From: Tim Screen <Tim.Screen@Cherwell-DC.gov.uk>
Sent: 17 August 2021 15:32
To: Caroline Ford <Caroline.Ford@Cherwell-DC.gov.uk>
Subject: 21/02337/DISC - Proposed Himley Village North West Bicester, Middleton Stoney Road, Bicester,

8 (site wide Masterplan and Design Code):

17 (means of footway and cycleway links):

19 (detailed surface water drainage scheme):

TITLE
PRELIMINARY DRAINAGE ASSESSMENT
500 UNITS SHEET 2 OF 4

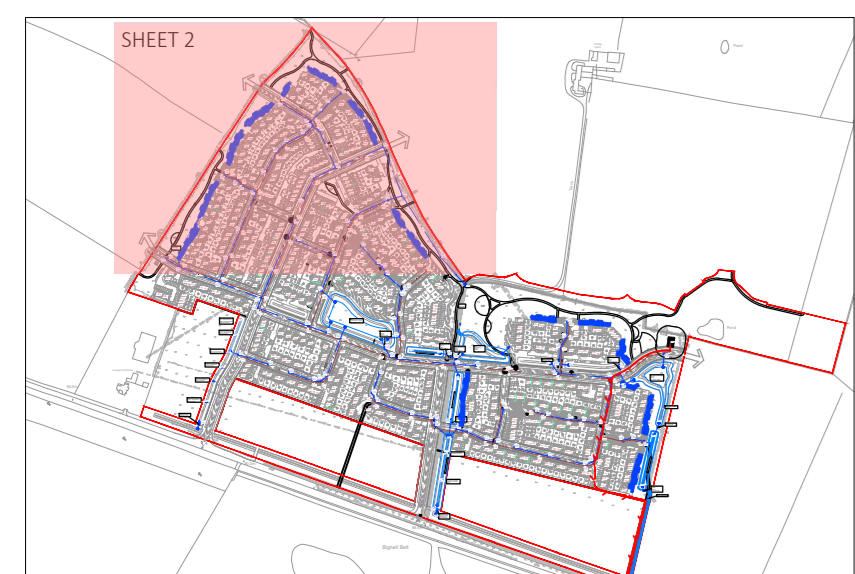
The SUDS basins are standard engineered features that require an integrated landscape approach. Let's see some design flare akin to the original designs for the Exemplar site.
